ACCESS REPORT

BIOLOGICAL SCIENCES PROJECT

BOTANY STREET, KENSINGTON UNIVERSITY OF NSW

SSD 6674 SUBMISSION

Sheet Name
FLOOR PLAN - LOWER GROUND

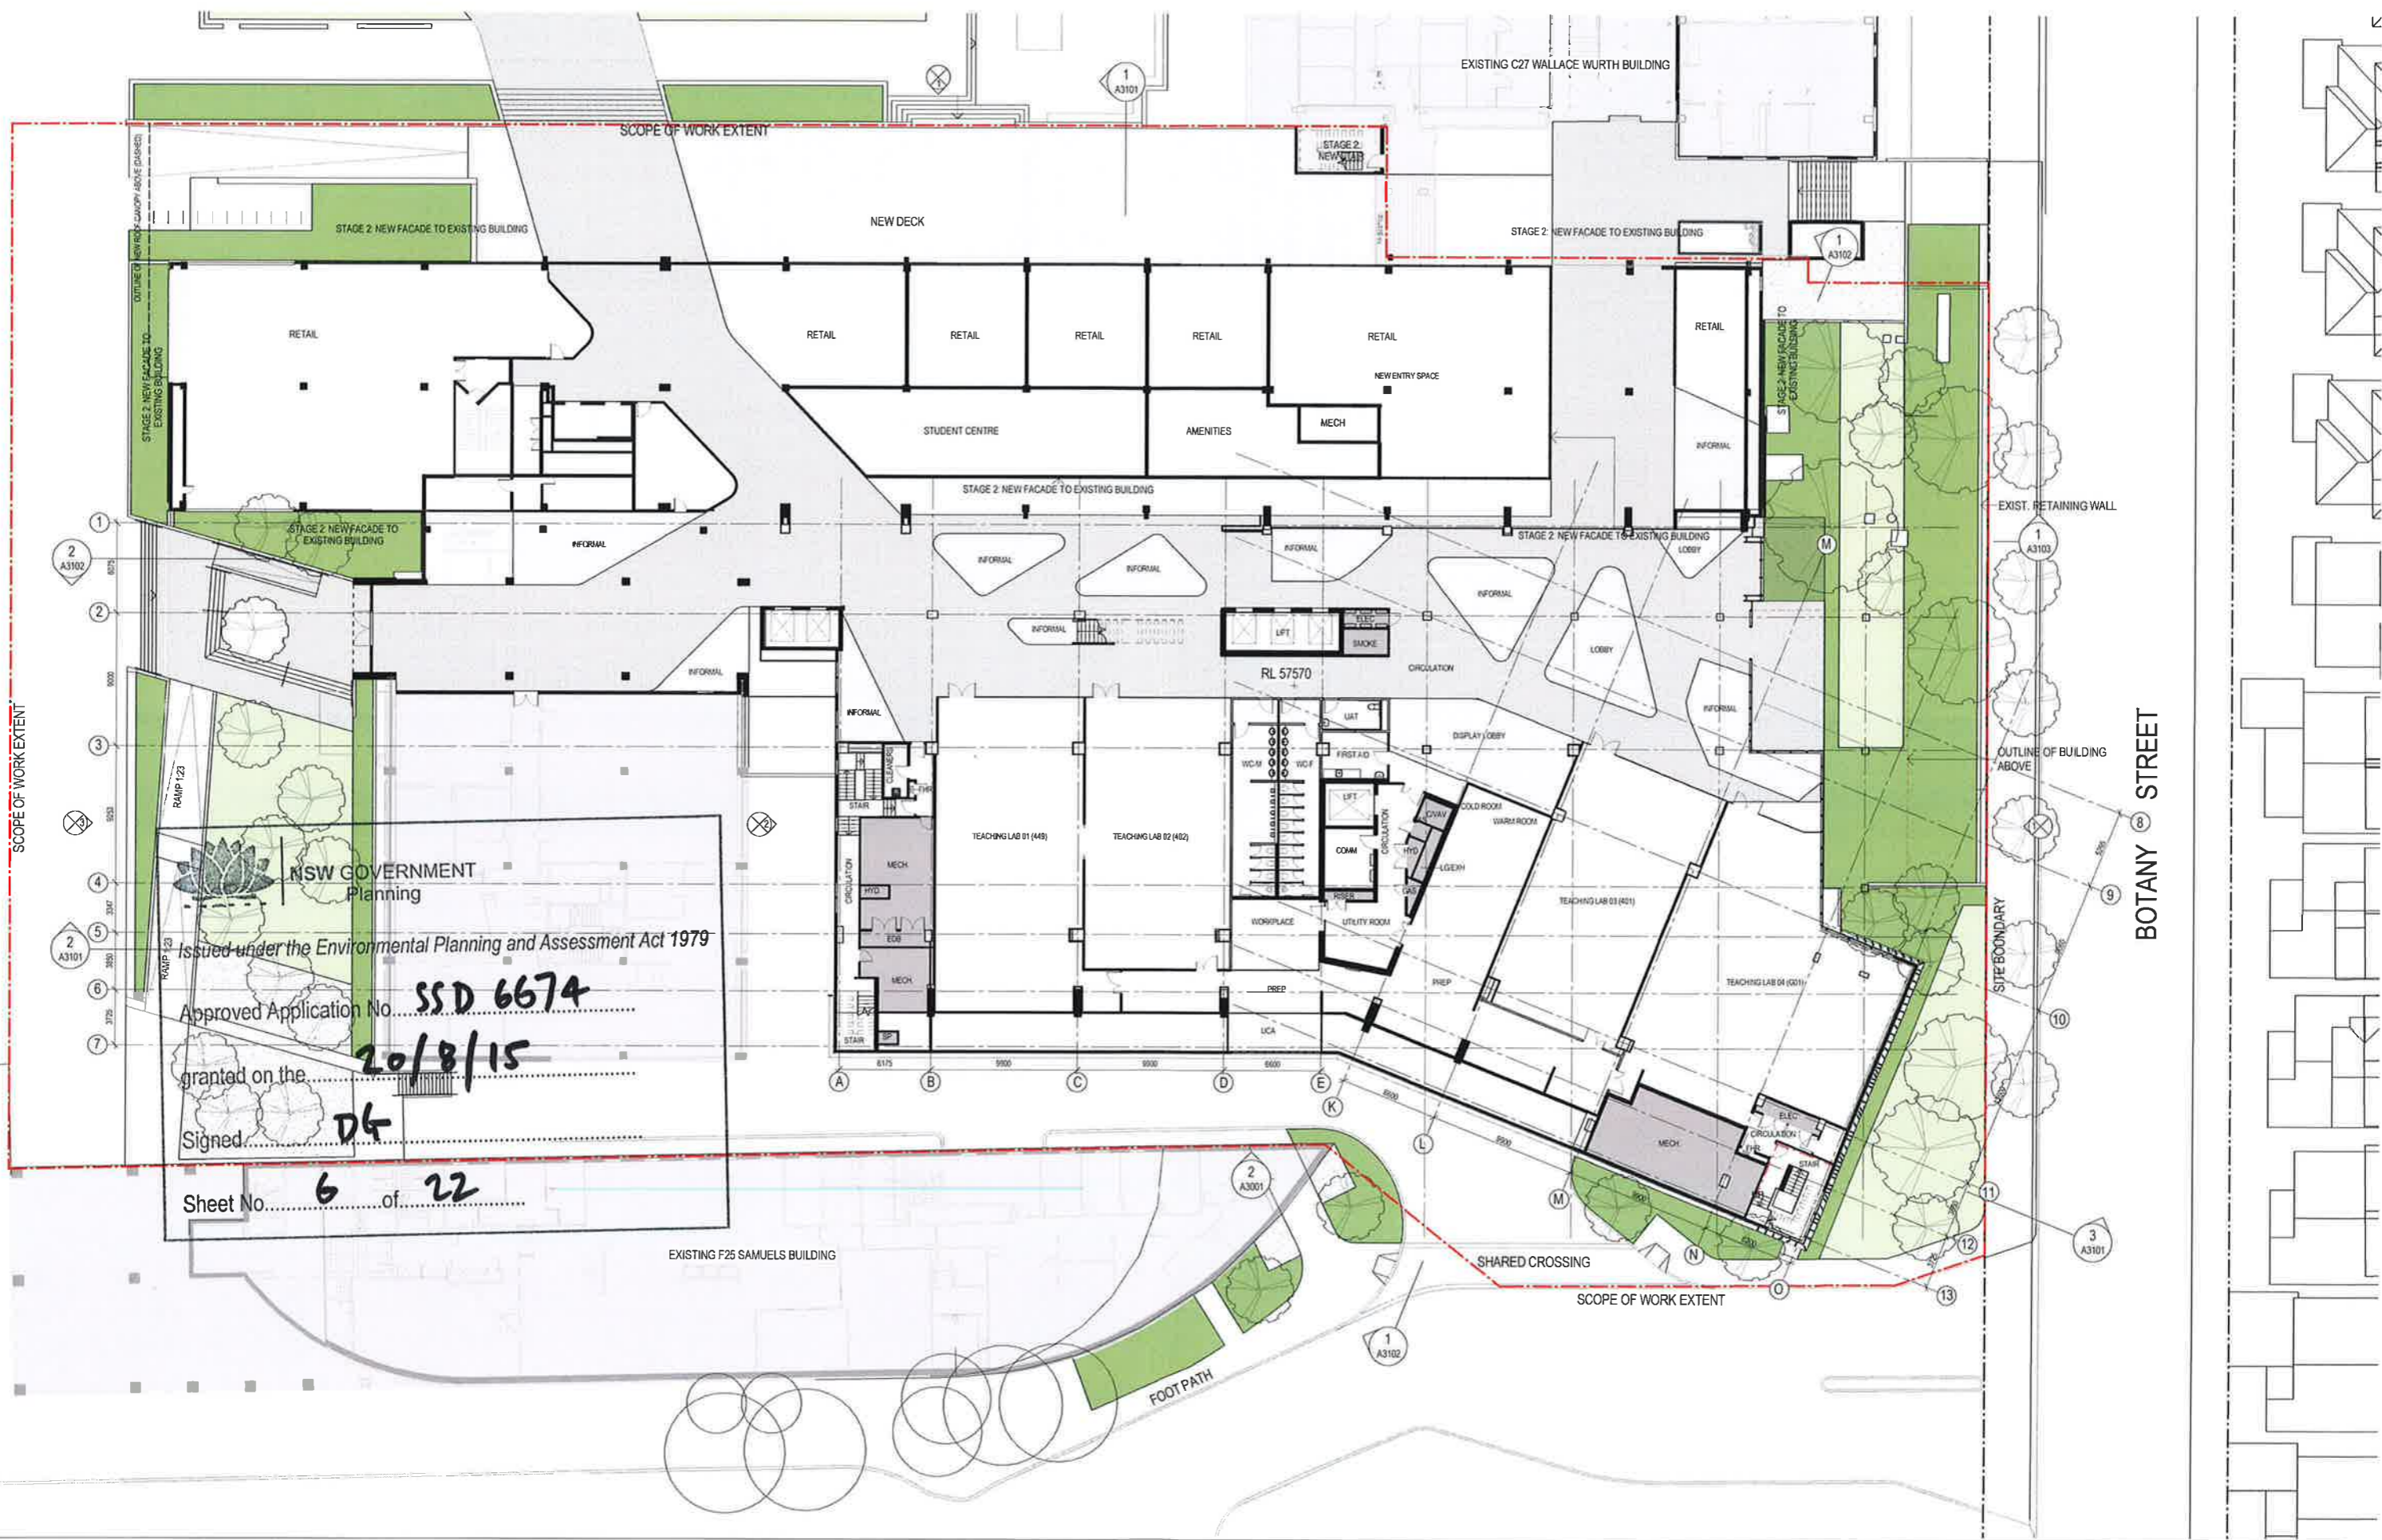
| <p>8. Entrances – At the lower ground floor the plans propose an entry doorway with at-grade access that enables access to a corridor and lifts. The split level design of the lower ground floor incorporates ramps and a lift which has dual ended doorway openings to access the split levels and thereby facilitate equitable access at this level in a manner consistent with ASI428.1 to satisfy Part D3.2 of the BCA and DDA Access Code.</p> | <p>YES</p> |
| <p>9. There are several other external doors at the lower ground floor that can facilitate independent accessible entrances to the Field Gear Prep, Chiller room, Dive gear room and the south-western corridor to achieve equitable access to</p> | <p>YES</p> |

| BCA / DDA Access Code Review | Complies |
|--|-------------------------------------|
| <p>12. Lower Ground Floor Level – The central lift landing provides 3000mm width while the central access corridors propose varying widths of 1600mm-1800mm generally and 2000mm minimum leading to the larger goods/passenger lift.</p> <p>13. The layout of doorways adjoining the central corridors will provide appropriate doorway circulation spaces, 1540mm X 2070mm Turning areas and 1800 X 2000mm Passing bays at the 90 degree turn and 20 maximum intervals in accordance with ASI428.1 to satisfy Part D3.3 of the BCA and DDA Access Code.</p> | <p>YES</p> <p>YES</p> |
| <p>14. The majority of other internal doorways to secondary rooms also provide appropriate doorway circulation spaces complying with ASI428.1 while the use of several plant and equipment rooms will be exempt from disability access requirements due to the uses, which may affect the health of people with disabilities. Such rooms shall be deemed exempt consistent with Part D3.4 of the BCA and DDA Access Code.</p> <p>15. The sanitary facilities adjacent to the central lift landing indicate appropriate access in accordance with ASI428.1 to satisfy Parts D3.3 and F2.4 of the BCA and DDA Access Code, which will be confirmed at a future construction documentation stage.</p> <p>16. With respect to the interface with the adjoining existing building the plans propose two doorways; one double doorway adjoining the lifts and a second door to the western end of the building.</p> | <p>YES</p> <p>YES at CC stage</p> |
| <p>17. While the double doorway inherently provides appropriate circulation spaces the single western door shall require an adjustment to achieve 530mm latchside clearance with a 920mm door.</p> |  <p>YES Can comply</p> |

| BCA / DDA Access Code Review | Complies |
|--|---|
| <p>47. Lower Ground Floor level provides a central group of sanitary facilities that includes a unisex wheelchair accessible toilet unisex while the male and female facilities will require detailing of ambulant accessible toilets.</p> |  <p>YES</p> |

Drawing number
A2202

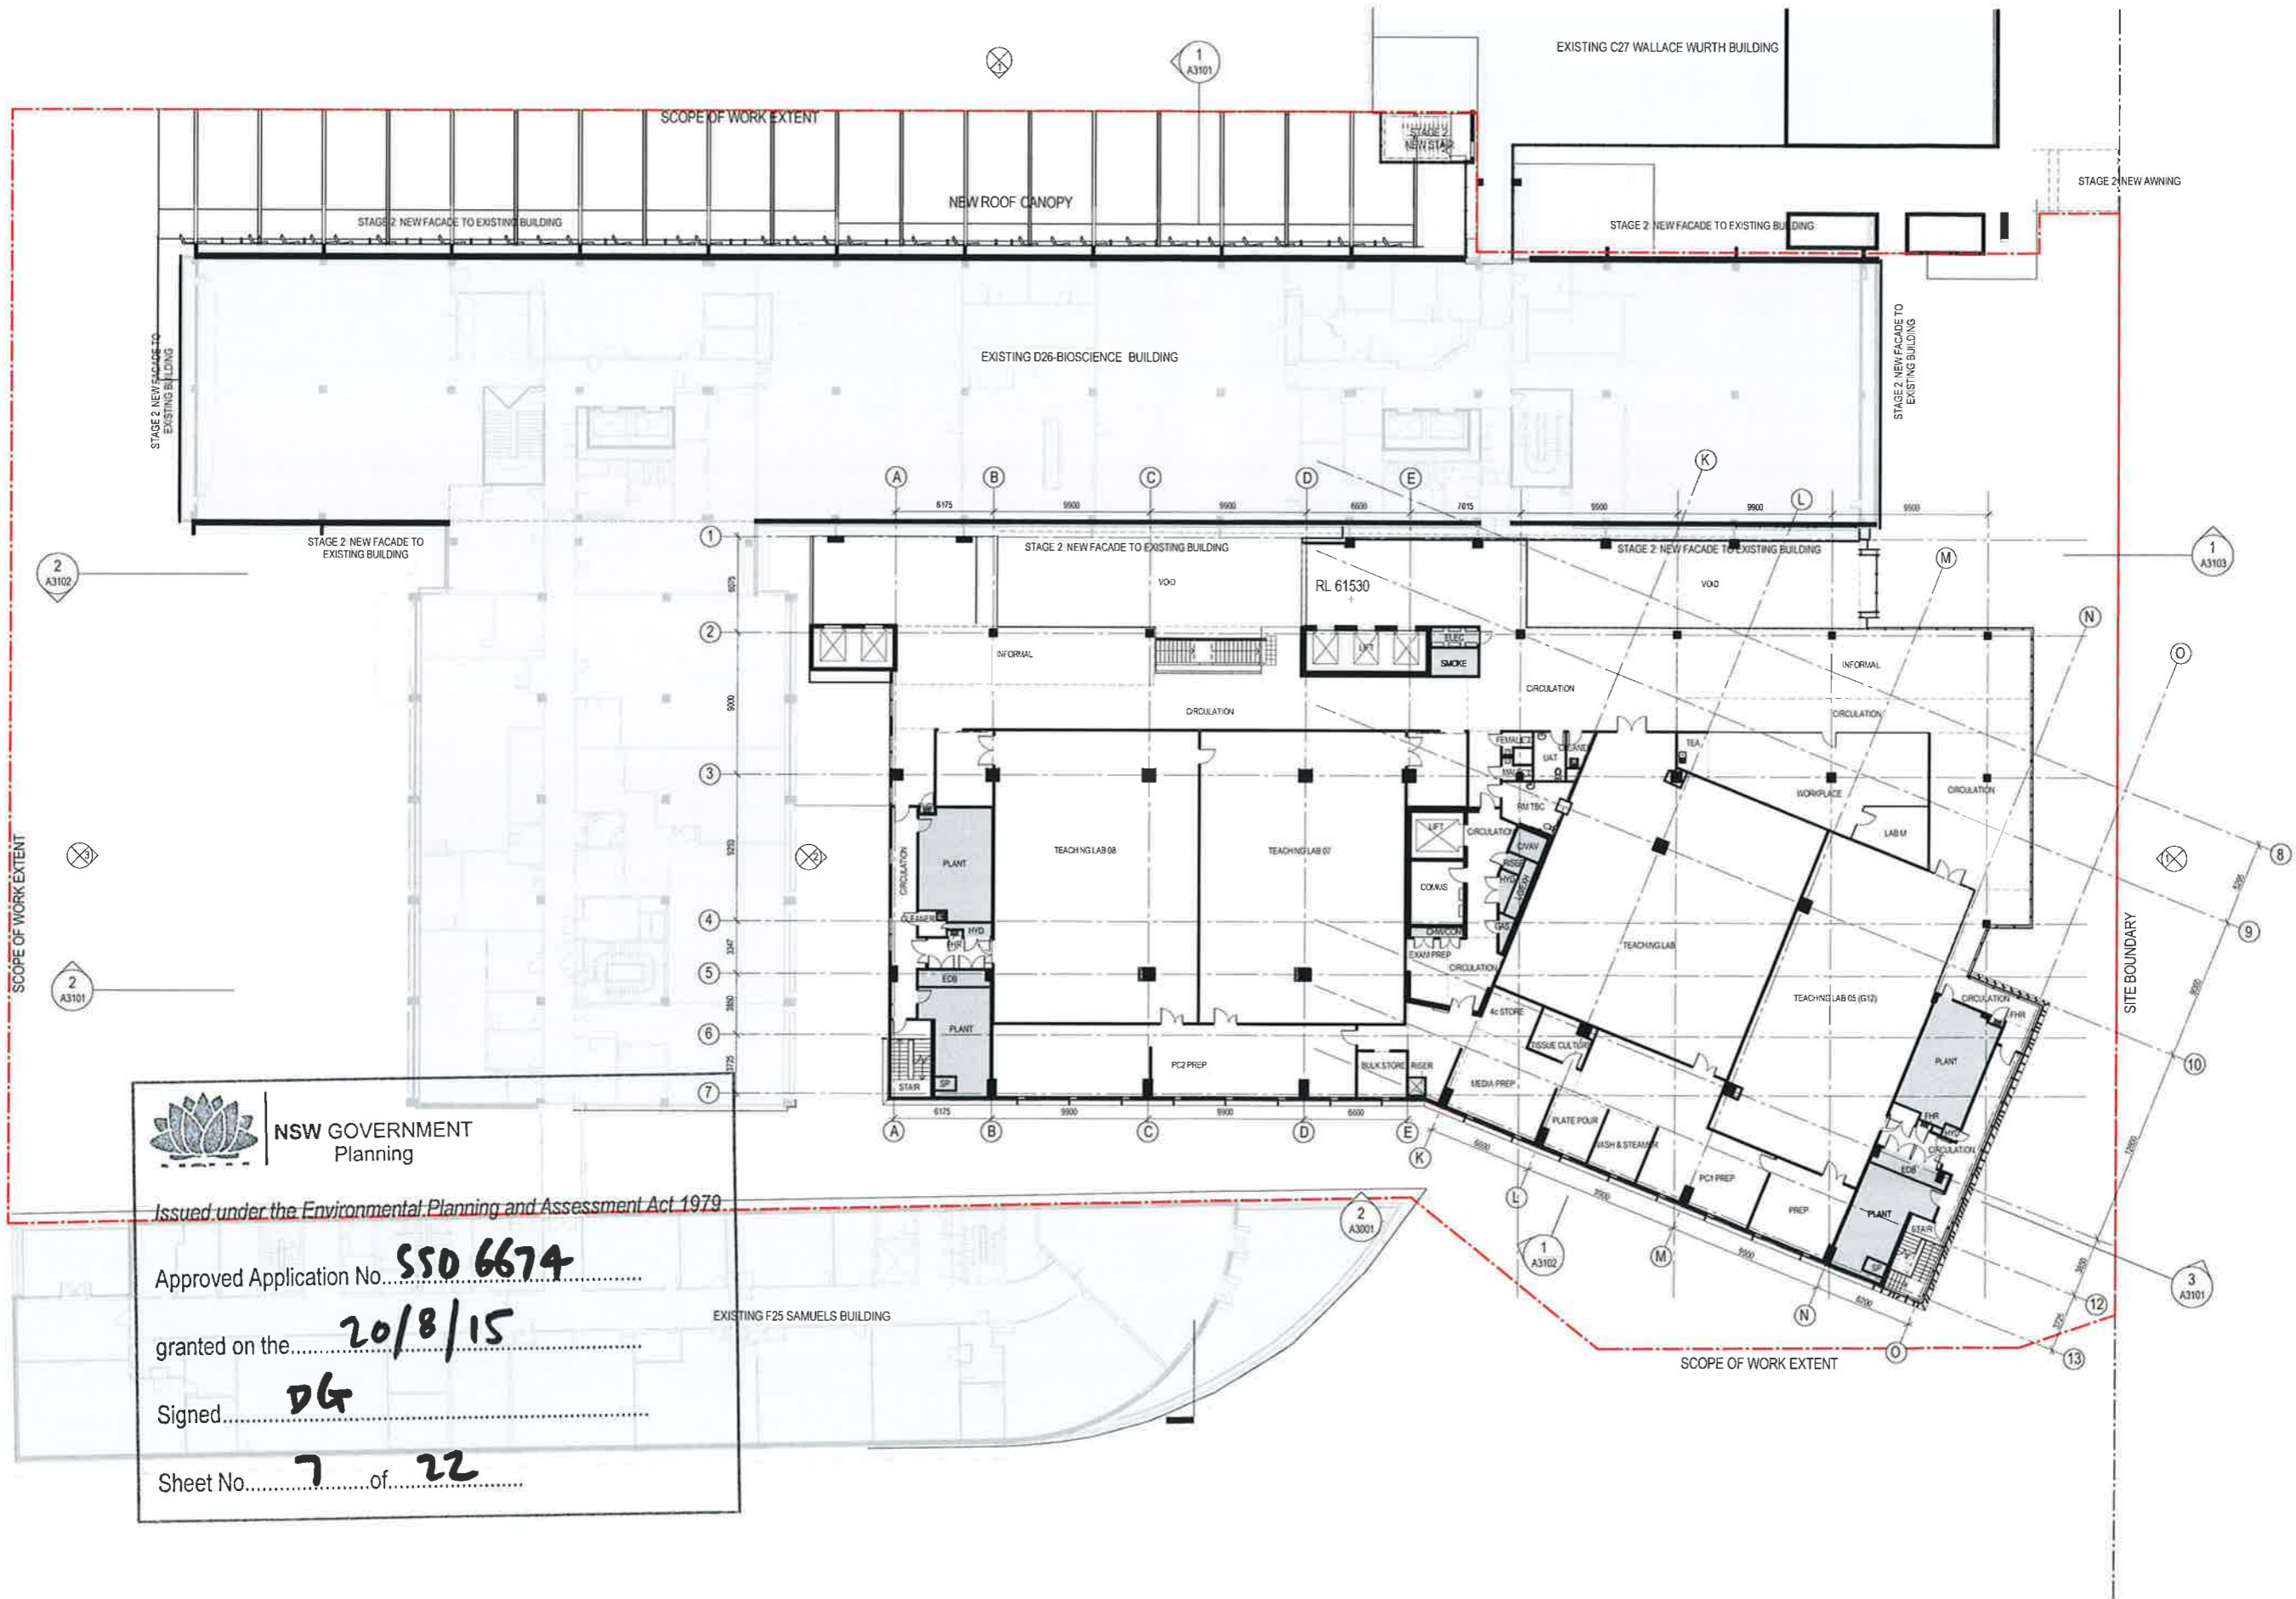
| BCA / DDA Access Code Review | Complies |
|---|--|
| <p>18. The open plan foyer areas provide ample circulation spaces to access all areas on the ground floor with an appropriate layout of doorways adjoining the corridors which facilitate doorway circulation spaces, Turning and Passing areas in accordance with ASI428.1 to satisfy Part D3.3 of the BCA and DDA Access Code.</p> | <p>YES</p> |

| BCA / DDA Access Code Review | Complies |
|--|-------------------------------|
| <p>19. The unenclosed stairway within the entry foyer shall require protection from headroom hazards and comply with ASI428.1 and ASI428.4.1 in all regards to satisfy parts D3.3 and D3.8 of the BCA and DDA Access Code.</p> | <p>YES</p> |
| <p>20. The sanitary facilities adjacent to the central lift landing can provide appropriate access in accordance with ASI428.1 to satisfy Parts D3.3 and F2.4 of the BCA and DDA Access Code, which will be confirmed at a future construction documentation stage.</p> | <p>YES</p> |

| BCA / DDA Access Code Review | Complies |
|--|---|
| <p>48. Ground Floor level provides a central group of sanitary facilities that includes a unisex wheelchair accessible toilet unisex while the male and female facilities will require detailing of ambulant accessible toilets.</p> |  <p>YES</p> |
